Our Ref: WA/54/19/NMA

Non-material amendment following the grant of reference WA/84/17/PL for change of colour of wall cladding and infill open bay with sectional door.

Fairmead Farm Land Binsted Lane Binsted Arundel BN18 0LQ

DRAWING No.
RA / 674 / 100 D

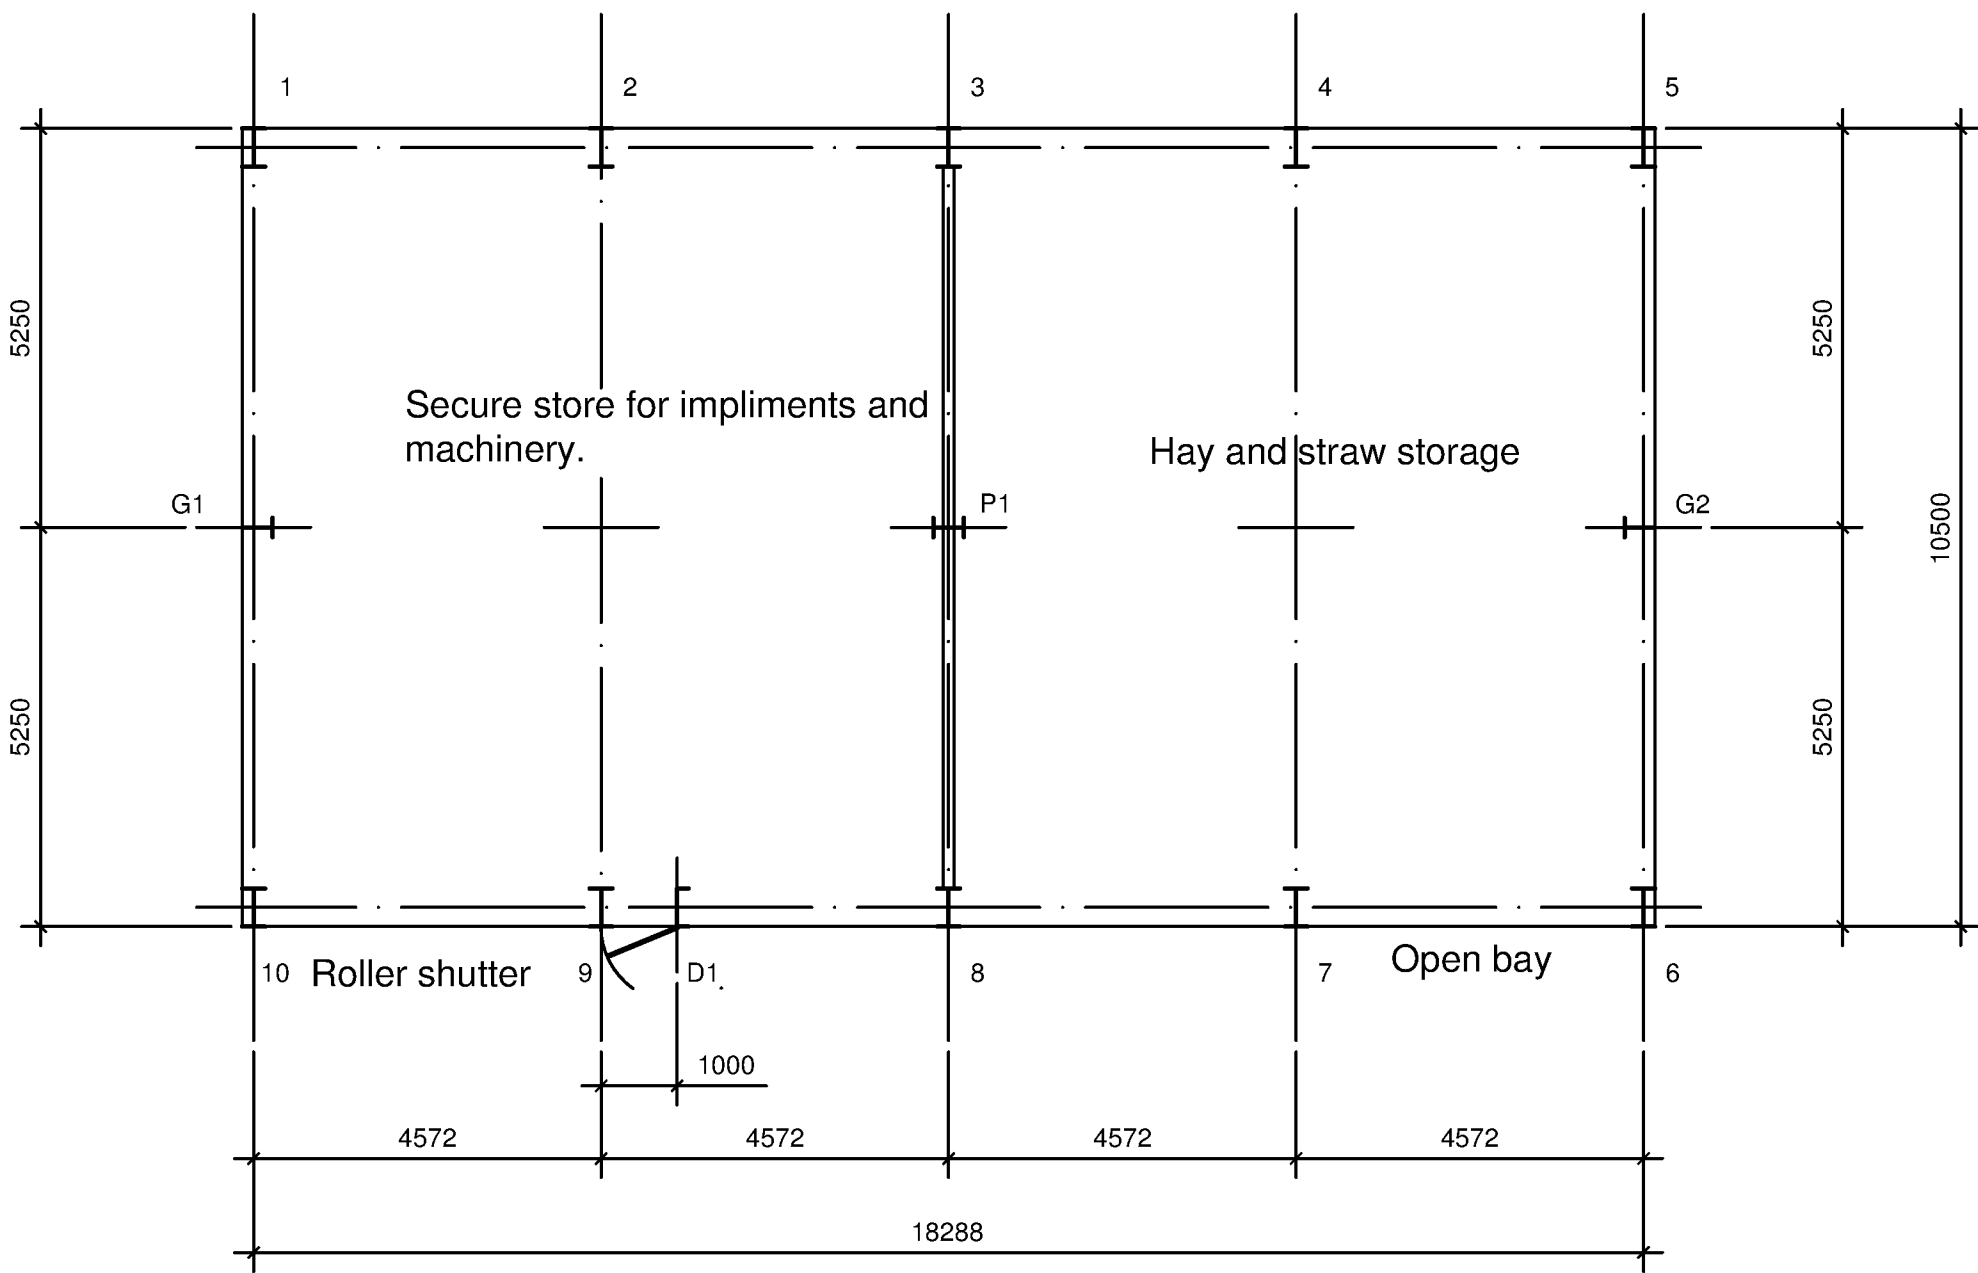
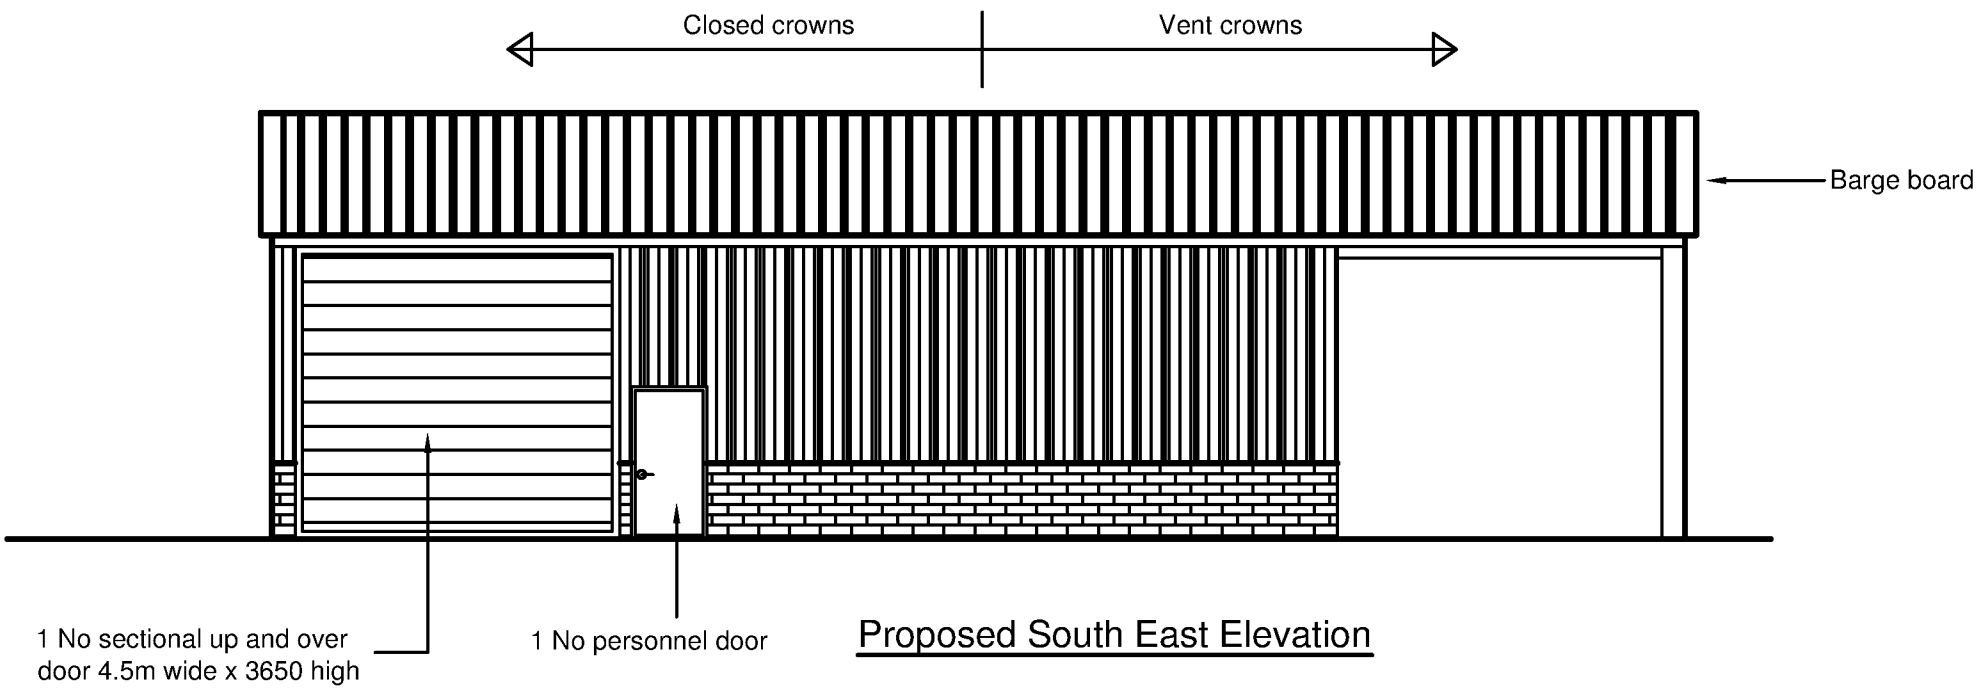
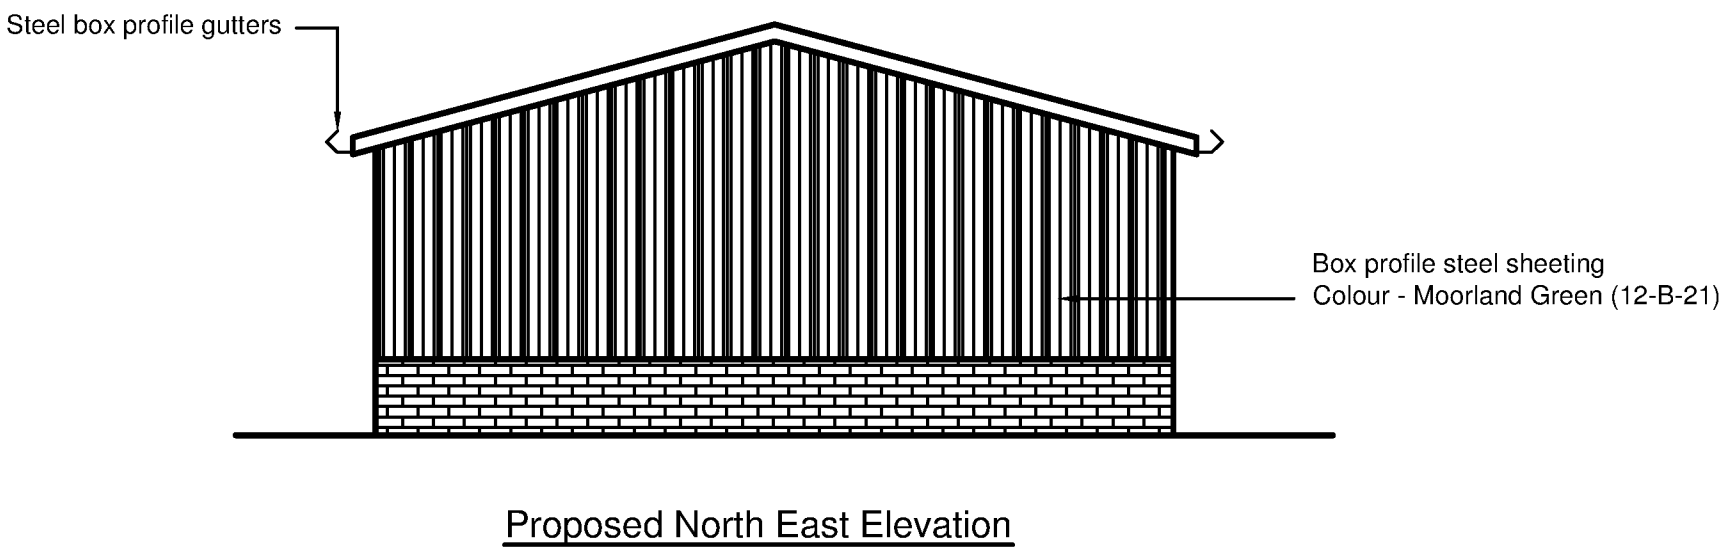
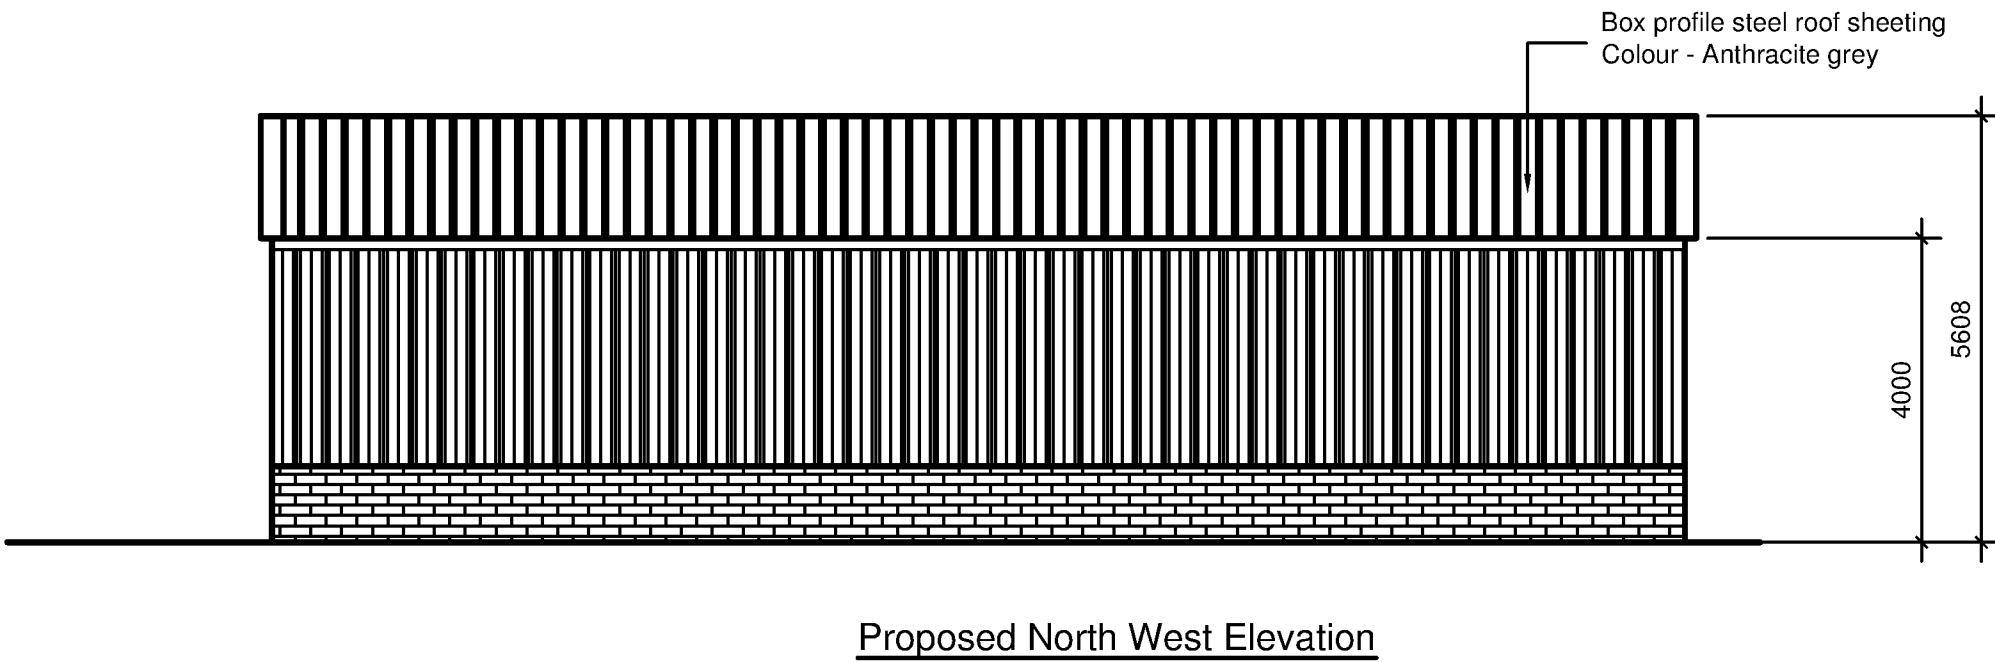
I refer to your recent application for a Non Material Minor Amendment. I note that you proposed to change the colour of the wall cladding, from green, to grey and also infill an open bay, with a roller-shutter door.

Please note that drawing number 'RA/674/100 - D' is replaced by 'RA/674/100 - F - Rev. 1'.
